Re: Status of Repair Application

An attempt was made to evaluate your property for the purpose of issuing a Repair Permit. The evaluation could not be completed for one or more of the following reasons.

Harnett County Department of Public Health Site Sketch

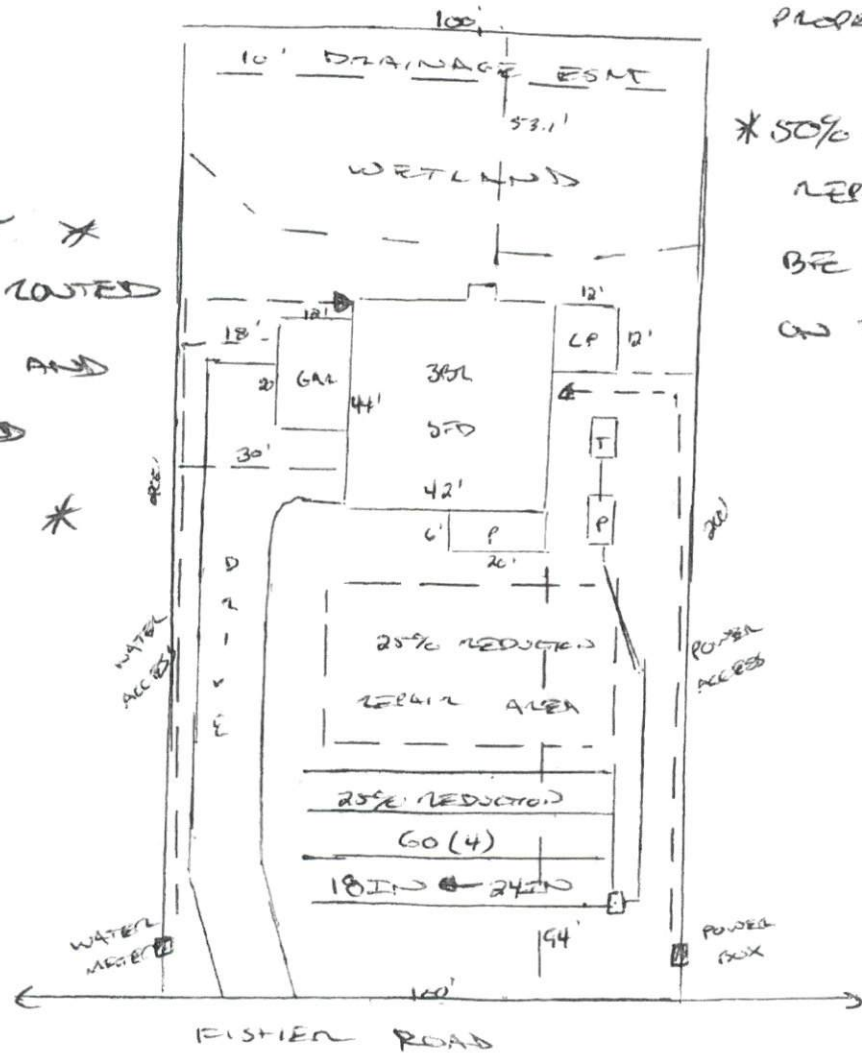
- ☐ 1. Use pink flags to mark property lines and irons that are
Set by surveyor need to be visible. Property lines to be marked/flagged every 50'.
- ☐ 2. Use orange flags to mark house box.
- ☐ 3. Directions not clear to property (\$25.00 fee incurred)
- ☐ 4. Property needs cleared
- ☐ 5. Driveway not shown on site plan (Revision Required)
- ☐ 6. Backhoe pits required
- ☒ 7. Other- Findings were that D-Box was not level, Gate Valve on pump needs to be slightly closed, Soil is missing near driveway on last 60' Line. Sewage was seen on surface of the last 60' Line at the end near driveway.

Discussed Options with applicant, have a septic Contractor Re-level the d-box, turn the gate valve and close it slightly, replace the missing soil.

If this does not work then, the new Repair system will be under the initial as a 50% T&J Panel. Applicant was informed to have their septic contractor of their choice to call environmental with any further findings among the Septic System.
